ENGLISH HERITAGE
SOUTH EAST REGION

Notifications under Circular 01/2001 & GDPO 1995

CHURCH FARM HOLIDAY VILLAGE, CHURCH LANE, PAGHAM, WEST SUSSEX.
Application No P/90/11/

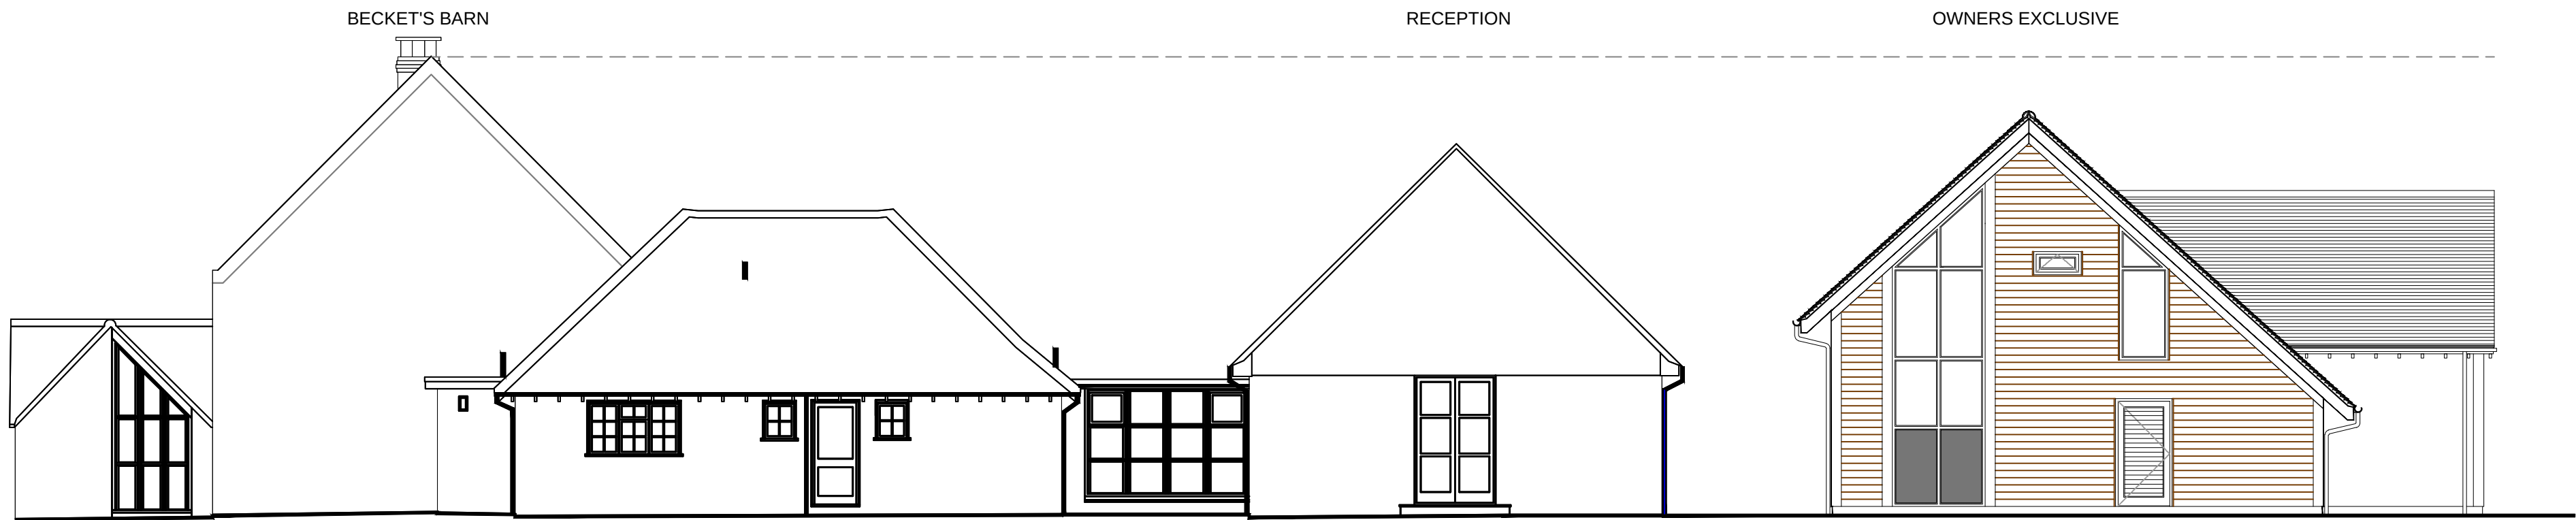
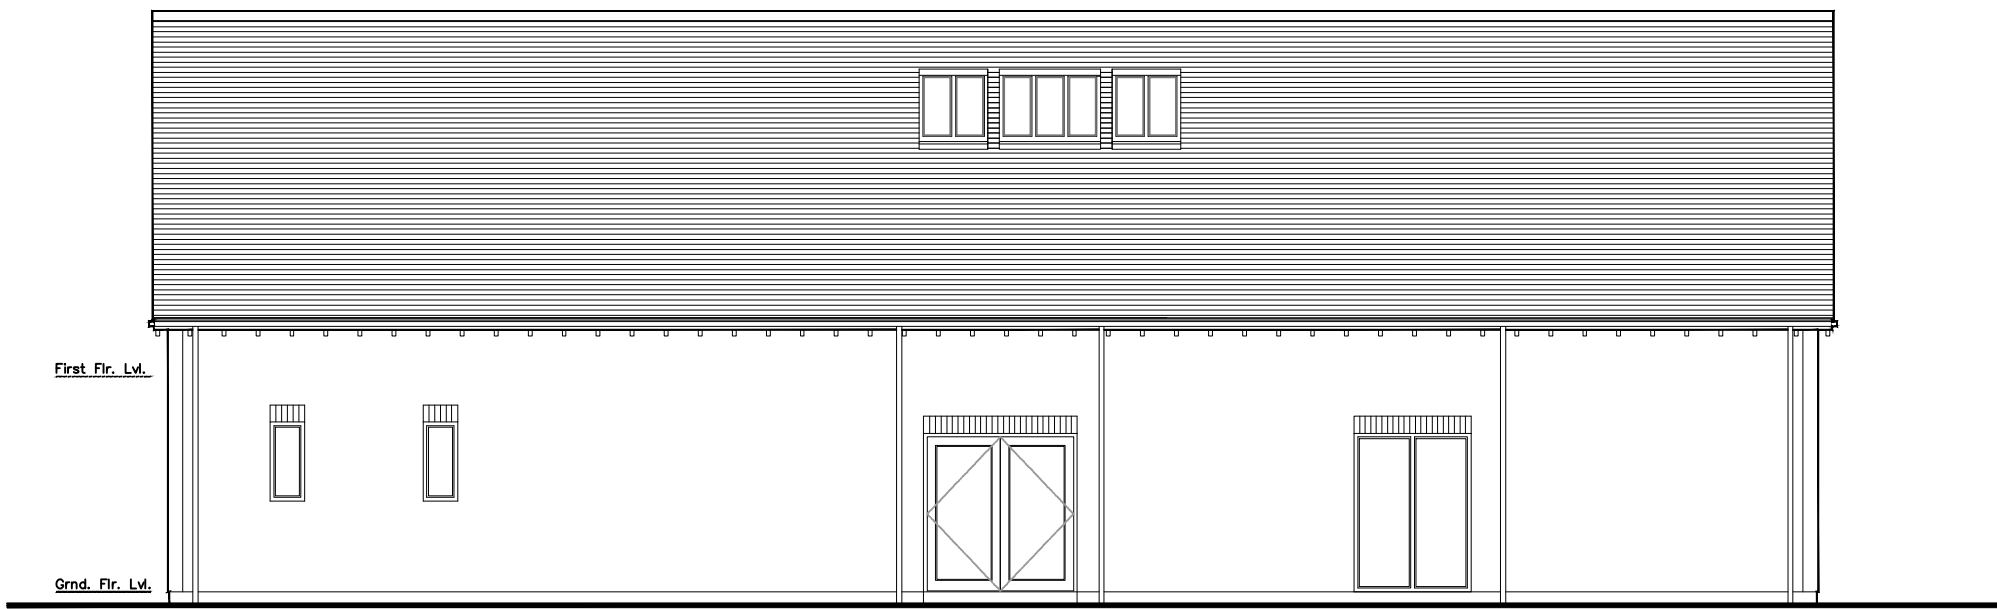
The proposed construction would represent an addition to the footprint and massing of the existing building, although as an incremental feature it should not represent any substantial additional adverse impact to the setting and historic character of the scheduled monument beyond that imposed by the existing recent development. While supplied plans offer no clear indication of proposed finish, materials or visual quality, it

is strongly recommended that these should be fully consistent with the design principles of the host building, with its simple lines and timber finish. In addition, it is anticipated that the associated garden, as an enclosed feature screened by plantings, would in time partly mitigate any adverse visual impact.

I therefore have no objection to this application, subject to approval of design details and to the satisfactory implementation of those conditions stated in scheduled monument consent.
